SUBJECT: SFD2303-0019
SINGLE FAMILY DWELLING

Here are the results of all Inspections located at **158 RETREAT DR:**

Inspection Type: ROUGH IN
Scheduled Date/Time: 4/10/2023
Completed Date/Time: 4/10/2023
Inspector: Justin Ryan McLeod
Result: DISAPPROVED
Remarks: eTRAKiT Inspection Request
Notes: 4/3/2023 7:52 AM Garman Homes

2ND FLOOR FRAMING PLAN
 ELEVATION B
 WALLS AND CEILING
 1/8" = 1'-0"

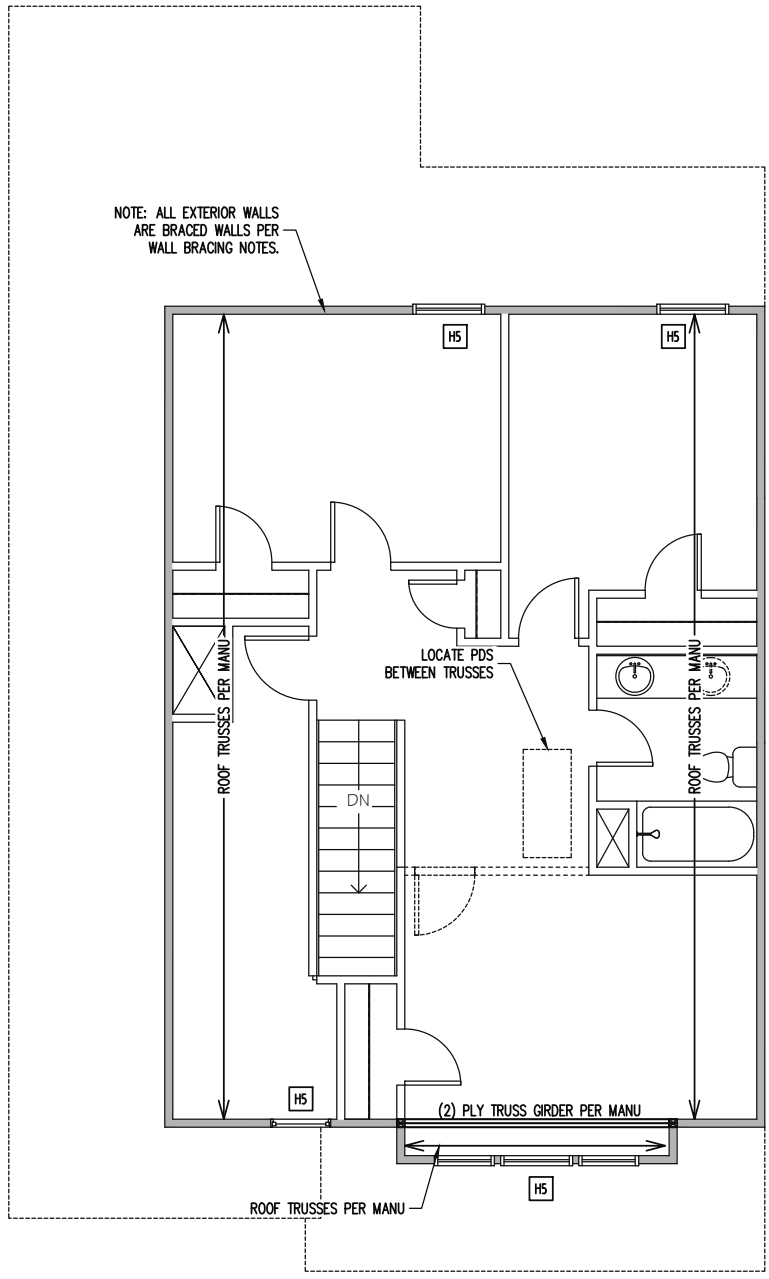
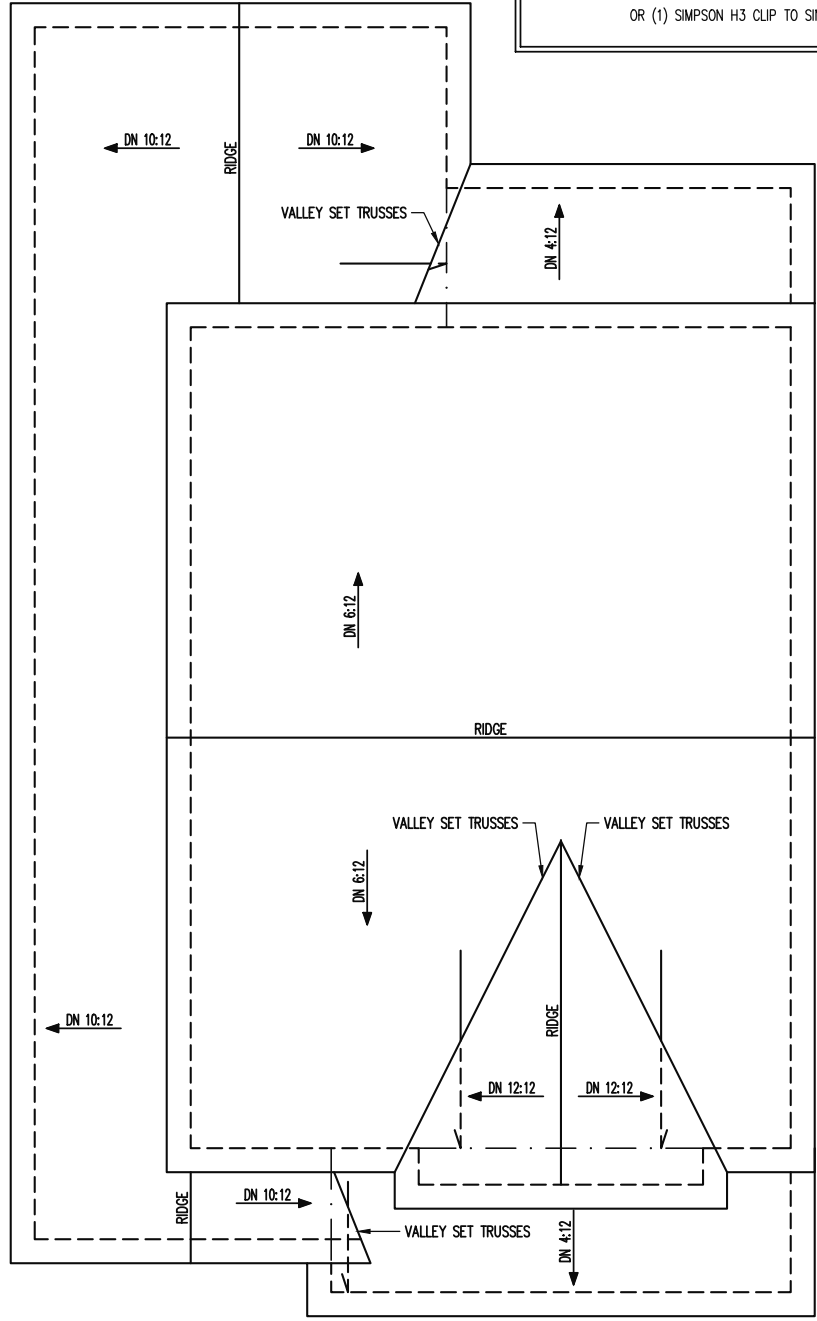
1. Missing hanger at lvl at stairs. 2. Fire blocking missing throughout. 3. 3 ply lvl nailed on both sides. 4. Dryer vent will need either wall furred out or chase built with top fireblocked. 5. Anchor bolt needed at cut bottom plate behind water heater. 6. Hanger missing at lvl in garage. 7. Trusses at lvl in garage need shimmed to bear on ledger. 8. Add king studs to upstairs triple window per sd2 section 17.01.. 9 fire rated sheathing must extend 4' into roof . 10. Hangers at pull downs. Do not insulate
